Re: Create a new lot as shown on the enclosed plan at 303 Auburn Street

Map 379 - F - 21 Book 31856 Page 36

CHECK-LIST AGAINST ZONING ORDINANCE

PLAN SHOWING PROPOSED DIVISION
AT 303 AUBURN STREET
PORTLAND, MAINE
MADE FOR
LINDSAY AND TYLER HOLDEN

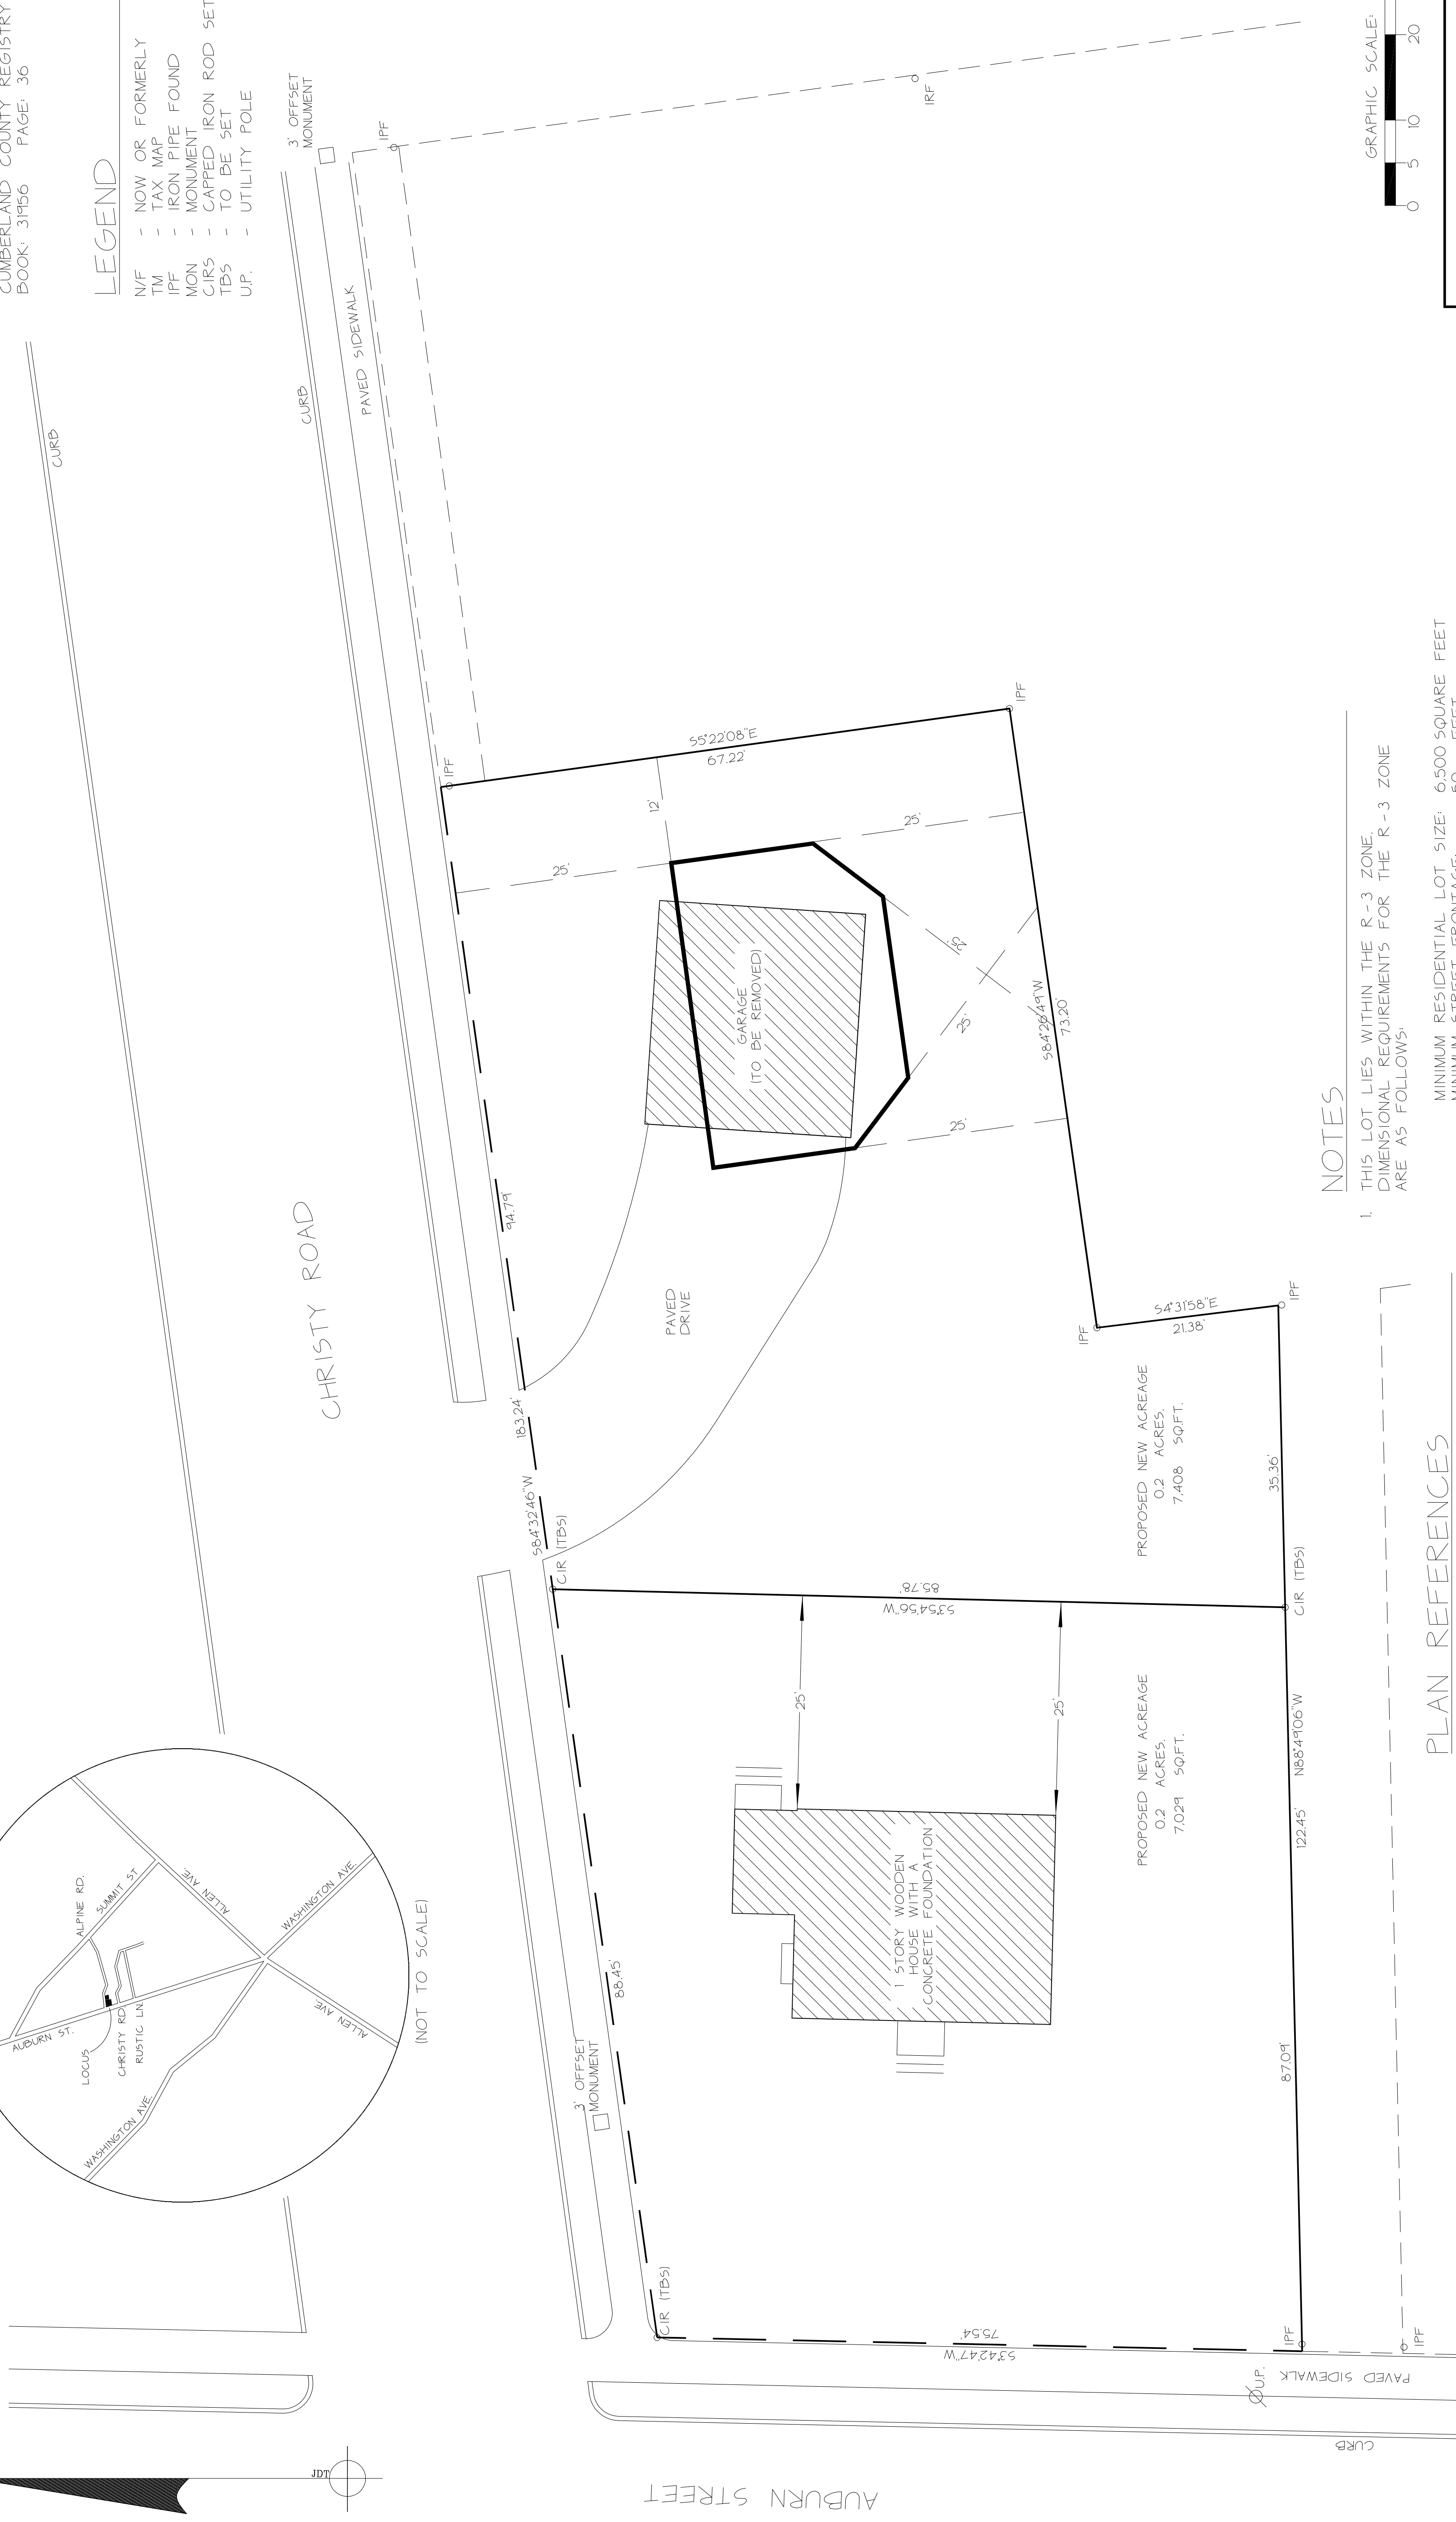
Side Yard - ~~15'~~ ^{or 1/2 street} 8'

Lot Coverage/ Impervious Surface - 25% = 24615[±] / 8445[±] ok.

* * driveway parking for existing lot.

* 25' building - 14-425.

* rear landing steps - 5.5 x 5 (275[±])
OK section 14-425.

*** footprint of new lot will be small
